# **AXIS J9 PHASE 3 TECHNICAL NOTE**

Response to OCC Highways Consultation Response

*(Application No. 21/03177/F) Under Cover  
Dated 7/12/21*

JOB TITLE		ALBION LAND	
DRAWING TITLE		HOWES LANE CROSSING	
SCALE	DRAWN BY	DATE	DRAWING No
1:125@A1	RM	08/03/22	14042-60-CY
REVISION			M

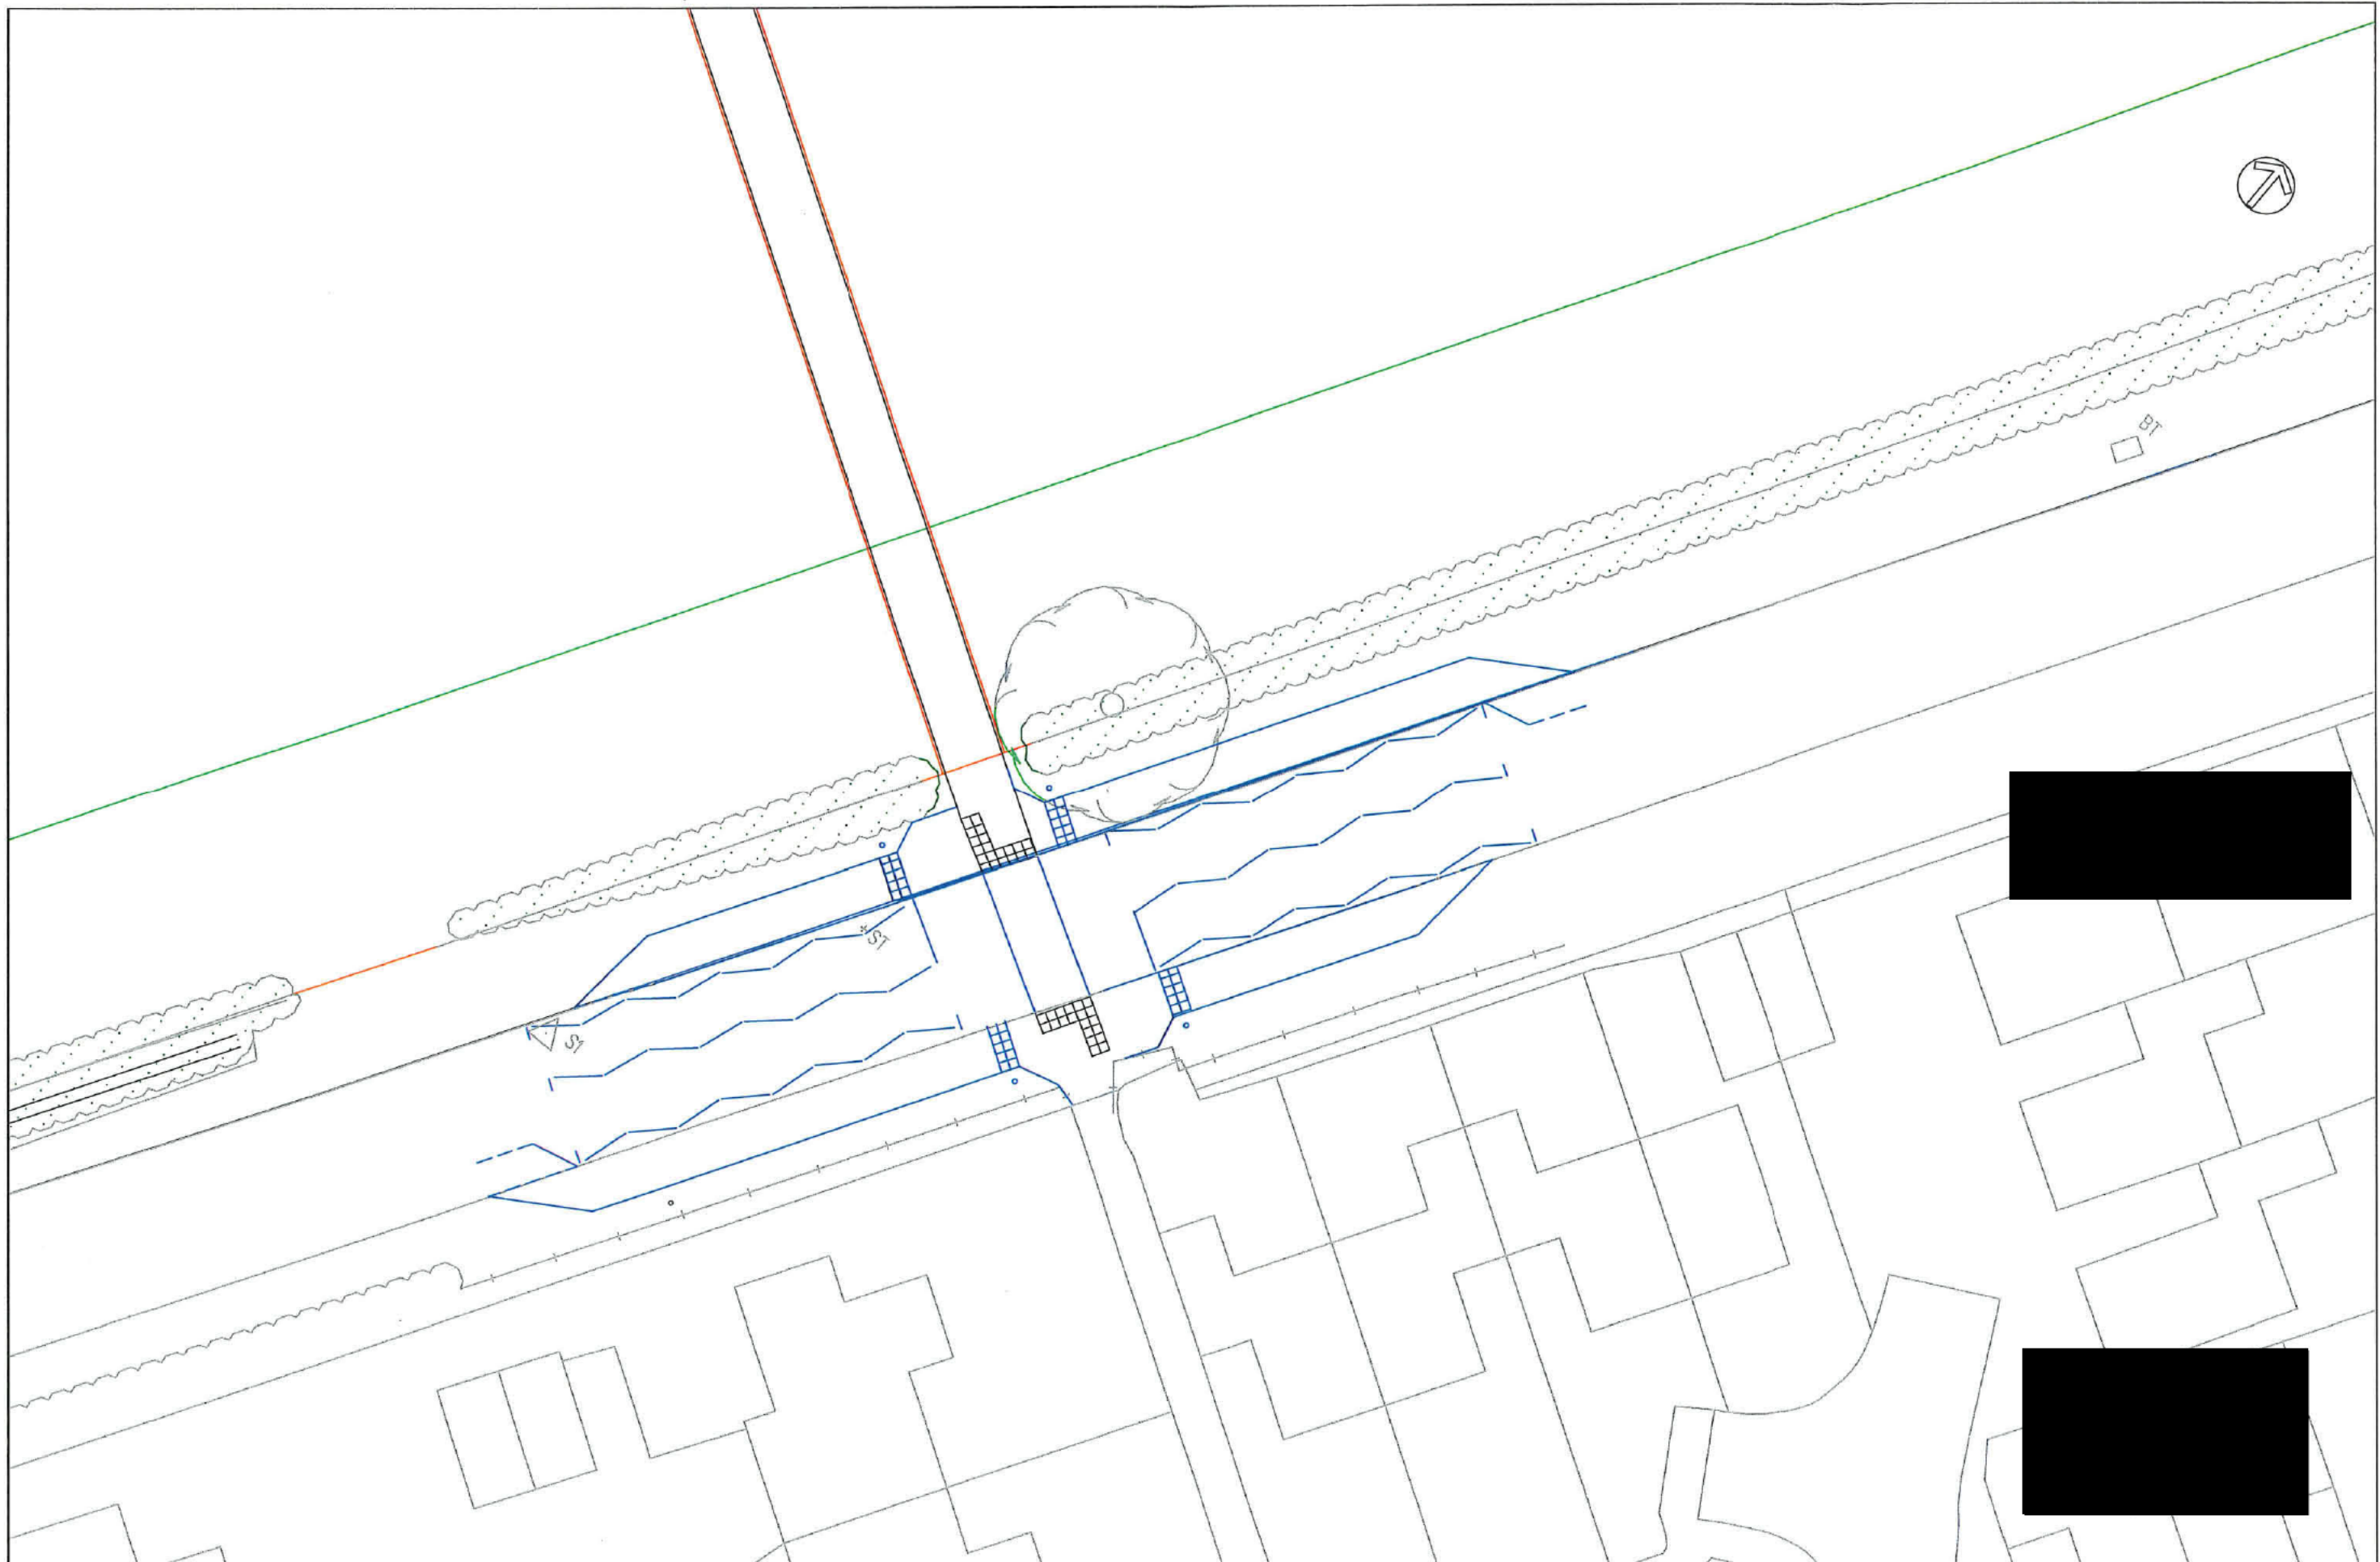
- v) OCC refer to the "Interim" period and the absence of direct linkage to the adjacent existing residential area to the east. The response further references pedestrian infrastructure secured under application 17/00455/HYBRID. Given the previously anticipated limited period (less than a year) under which it was envisaged that the "Interim" position would operate, it was not considered that the costs involved in such a short term pedestrian/cycle connection via Howes Lane were commensurate. Given that the "Interim" period is now liable to be more prolonged, it is proposed to promote pedestrian and cyclist linkage

through the eastern development parcel and a signalised pedestrian crossing on Howes Lane linking into the public footpath through to Wansbeck Drive. This is illustrated on the **DTA Drawing 14042-65** and the Proposed Site Plan TP\_002L (**Appendix B**) and the crossing detailing shown on **DTA Drawing 14041-65**.

38. A signalised crossing design is provided as discussed above.
